Attached is my response to National Grid Electricity Transmission plc's (the Applicant's) response to Action Point 27 addressed to the Applicant arising at Issue Specific Hearing 2 (ISH 2) held on 28 April, 29 April and 1 May 2026.

Interested Party Response to Action Point 27 from ISH2 EV9-023

Reference to Appendix E - Action Point 27 – Colne Valley (including Fordham, Ford Street, Aldham) Constraints and Opportunities Plans

Norwich to Tilbury
Figure: 7.12.F106_VP4.08e(ii)
Viewpoint 4.08: Fordham

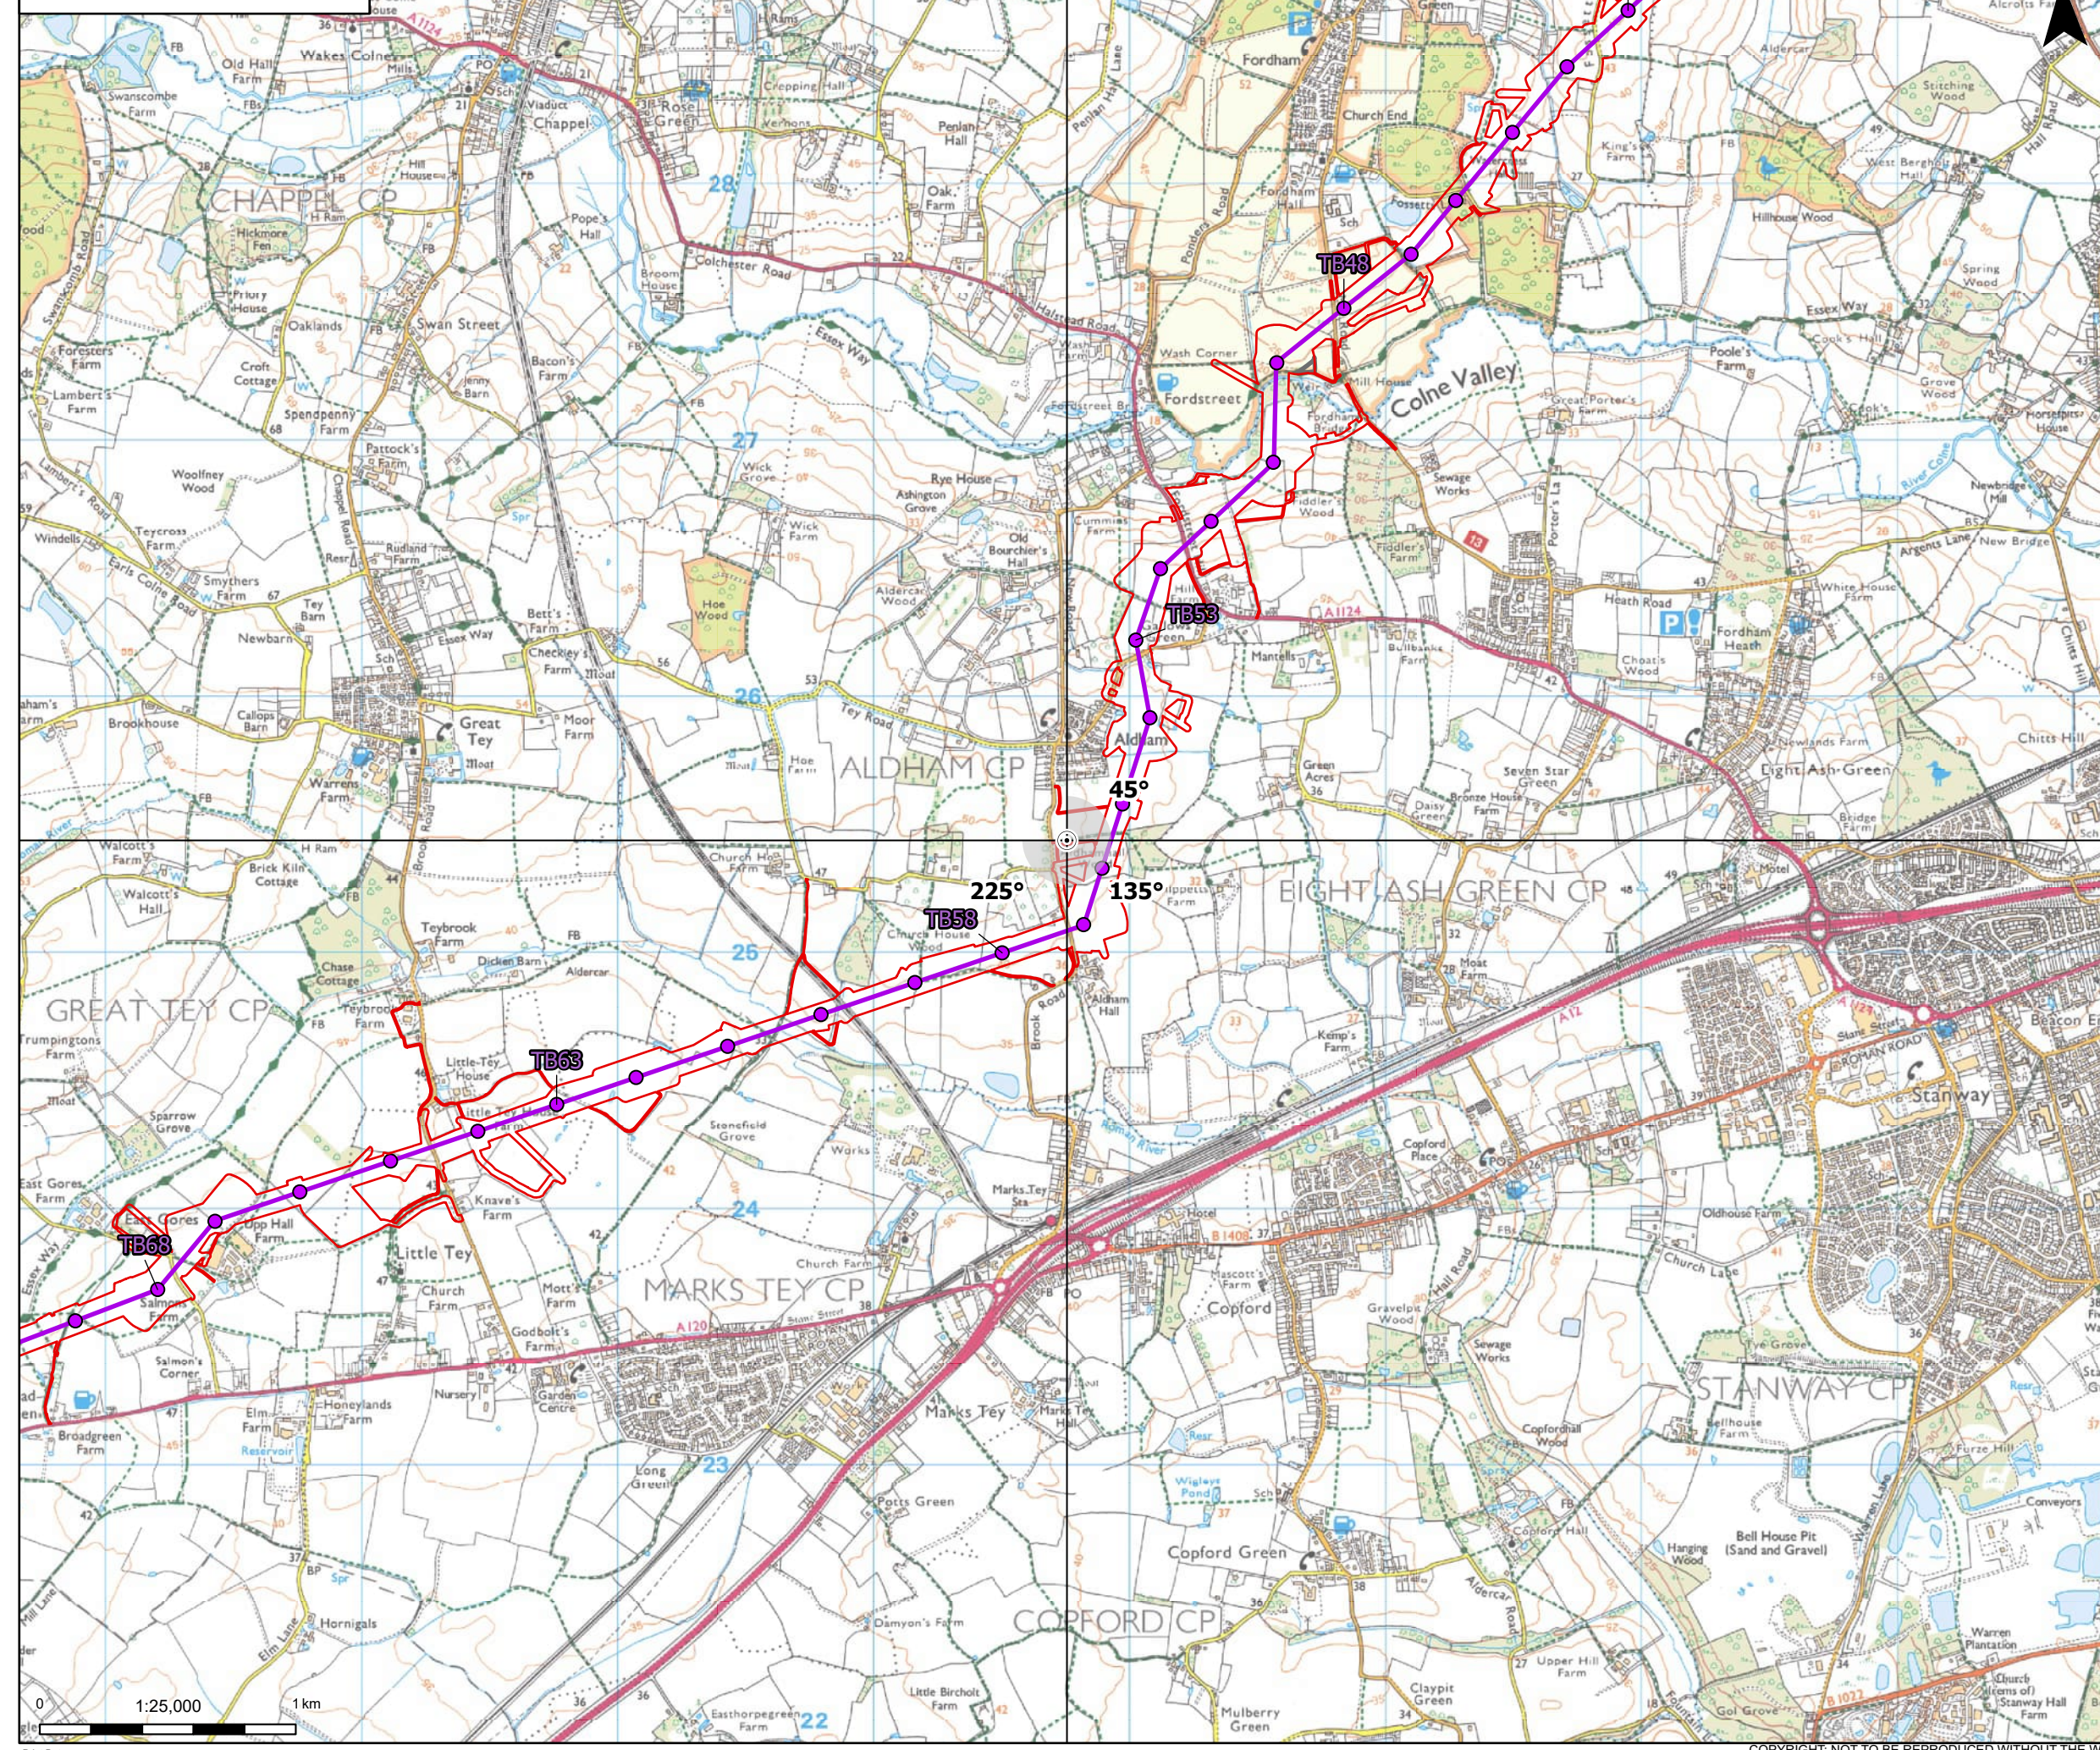
Proposed TB 48 & 49 will be situated in largely open pasture and are considerable elevated from the floor of the Colne Valley. These proposed pylons also cross a public amenity area – the Fordham Hall Estate – which has footpaths from which the pylons will be visible from miles away

The claimed direct route across the river valley will minimize effects on mature woodland. TB48, 49 & 50 are on largely unspoilt open pasture and countryside, creating jarring new visible structures that are out of scale to the surrounding area.
